Arun District Council
Arun Civic Centre
Maltravers Road
Littlehampton
West Sussex BN17 5LF
Planning & Building Control General Enquiries
Tel: (01903) 737756 Fax: (01903) 730442
Dx: 57406 Littlehampton
Minicom: 01903 732765
e-mail: planning@arun.gov.uk
website: www.arun.gov.uk/planning

Application No: M/92/20/HH
Site Address: 67-69 Lych Gate House Elmer Road Middleton-On-Sea PO22 6EH
Description of works: Two storey rear extension and single storey front extension, first floor front extension

Thank you for your internet representation made on 1st February 2021 which has been recorded as an objection with the comments as follows:

Proposed East Elevation

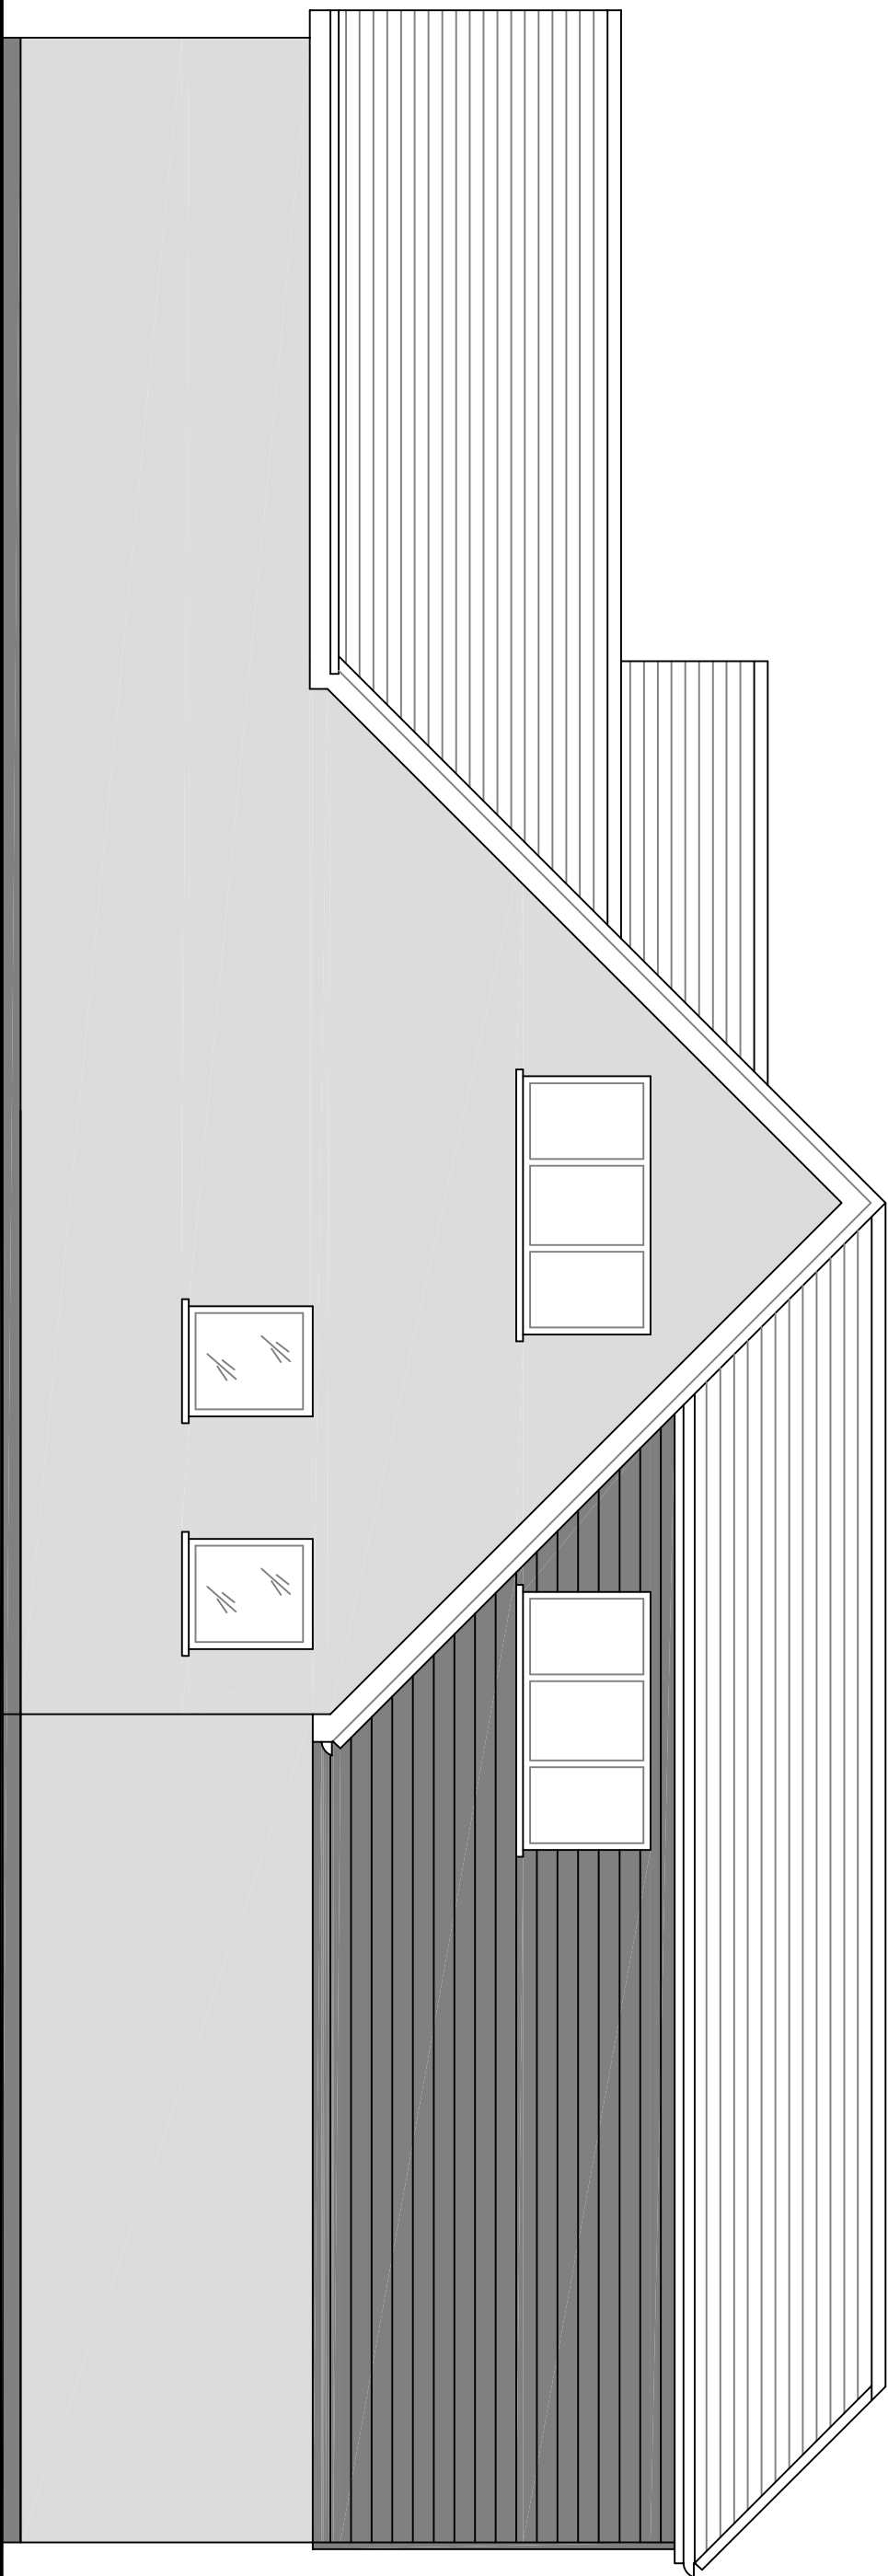
I am concerned that the ADC Planning Department has not contacted me in relation to my earlier comments. The sketch plan used in this application is more than 23 years out of date and doesn't show the correct footprint of my property and as a result the impact of the proposed extension has not been acknowledged. If no amendment is made and this building goes ahead, the windows on the upper floor on the east side will look directly into my main bedroom and kitchen/living area.
